CITY OF MERCER ISLAND

STAFF REPORT

CRITICAL AREA REVIEW 2 PERMIT

Project No.:	CAO23-032
Description:	A request for a Critical Area Review 2 Permit for the demolition of an existing single-family residence and construction of a new single-family residence located on a site containing geologically hazardous areas.
Applicant / Owner:	Erik Voris / Day, Leslie A and Richard L
Site Address:	9843 Mercerwood Drive, Mercer Island, WA 98040; Identified by King County Assessor tax parcel number 5456000490.
Zoning District:	Single Family Residential (R-8.4)
Staff Contact:	Molly McGuire, Planner
Exhibits:	<ol style="list-style-type: none">1. Revised Development Application, received by the City of Mercer Island on March 4, 20242. Development Plan Set, dated December 7, 2023 and received March 4, 20243. Project Narrative, received December 28, 20234. Concurrent Review Request Form, dated December 7, 2023 and received January 16, 20245. Critical Areas Notice on Title, recorded March 19, 2024 under King County Recorder's Number 202403190003516. Hazard Report, generated by the City of Mercer Island on February 14, 20247. Determination of Complete Application, dated January 10, 20248. Notice of A

L1.1

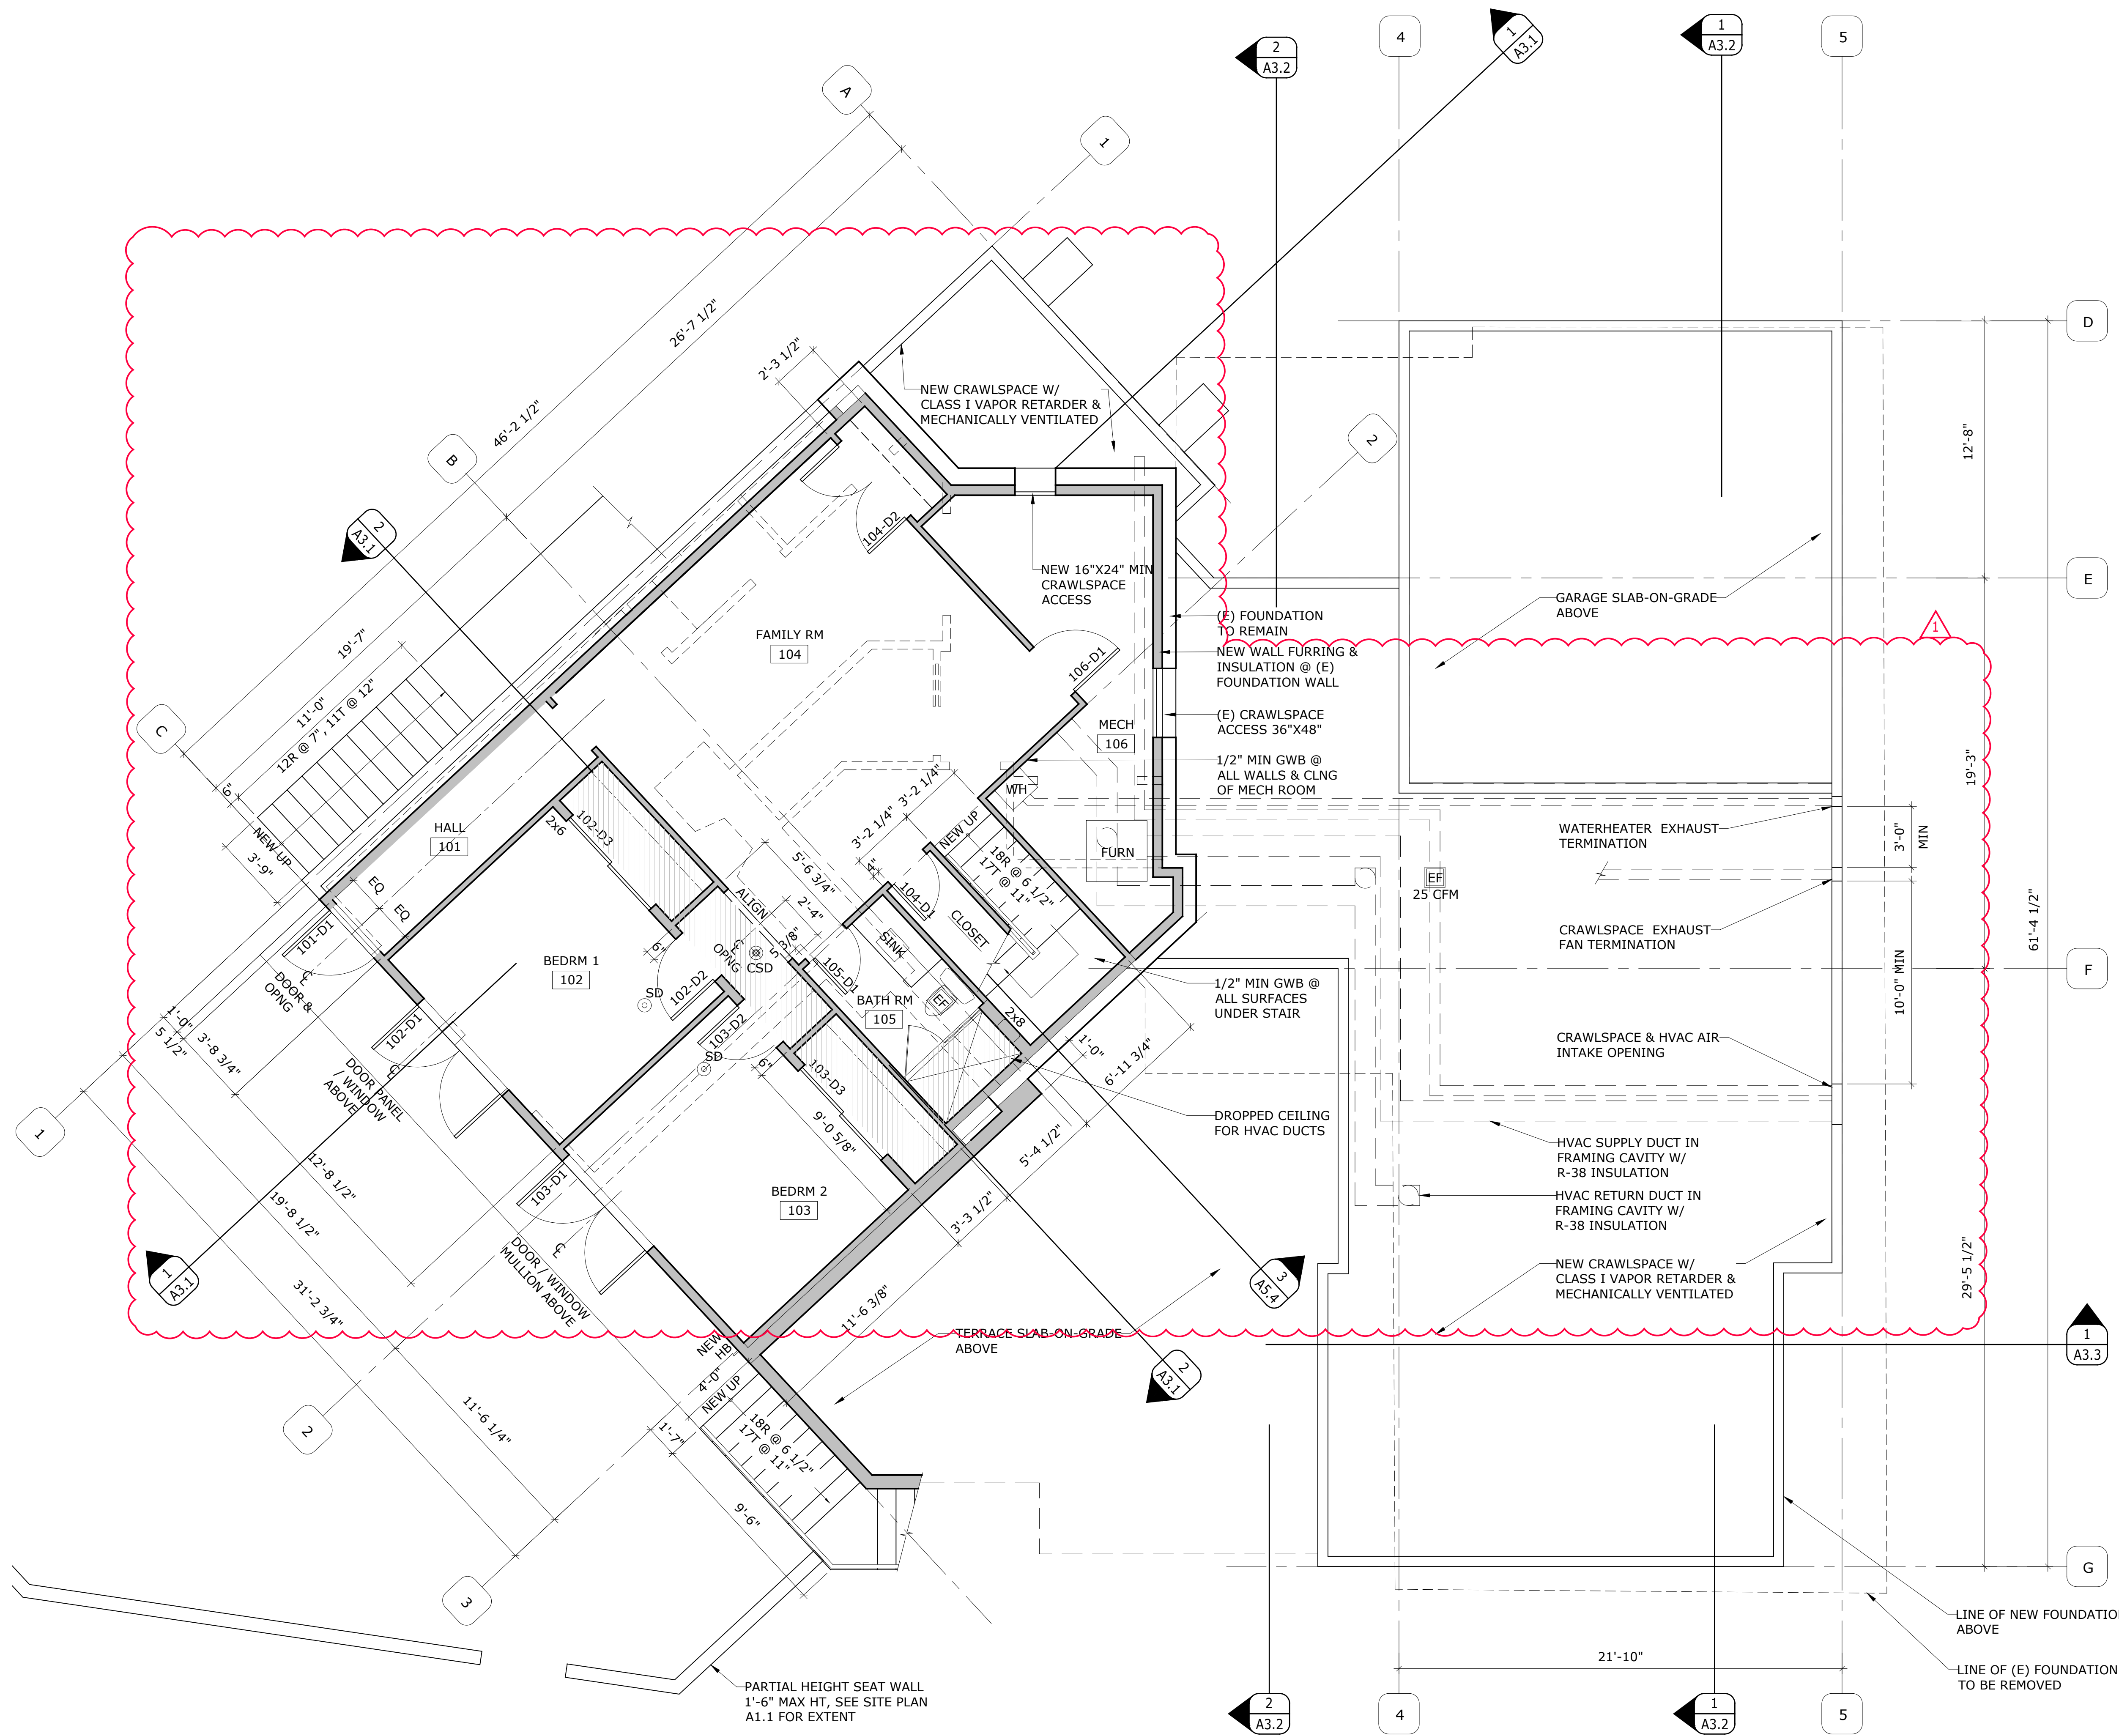
Staff Analysis: The applicant provided an Addendum to Geotechnical Report and Critical Area Study – Critical Area Mitigation Sequencing (**Exhibit 12**) which addresses mitigation sequencing for the proposed development. The entire development site is encumbered by potential slide and erosion geologically hazardous areas, and the northern portion of the property contains a seismic hazard area (**Exhibit 6**), therefore; avoiding the impact altogether is not possible. The applicant proposes to minimize the impact by only proposing work within the gently-to moderately sloped portions of the property and designing the project to provide substantial improvement for seismic hazard protection. The project also includes the restoration of the affected environment through the proposed landscaping plan, which includes the landscaping of all disturbed areas outside the proposed building footprint (**Exhibit 2, Sheet L1.1**).

report are followed, the planned development will not adversely impact the stability of the neighboring properties or result in a need for increased critical area buffers on those adjacent properties. The proposed development includes a landscaping plan that includes the landscaping of all disturbed areas outside of the building footprints and installation of hardscape, required prior to final inspection (**Exhibit 2, Sheet L1.1**).
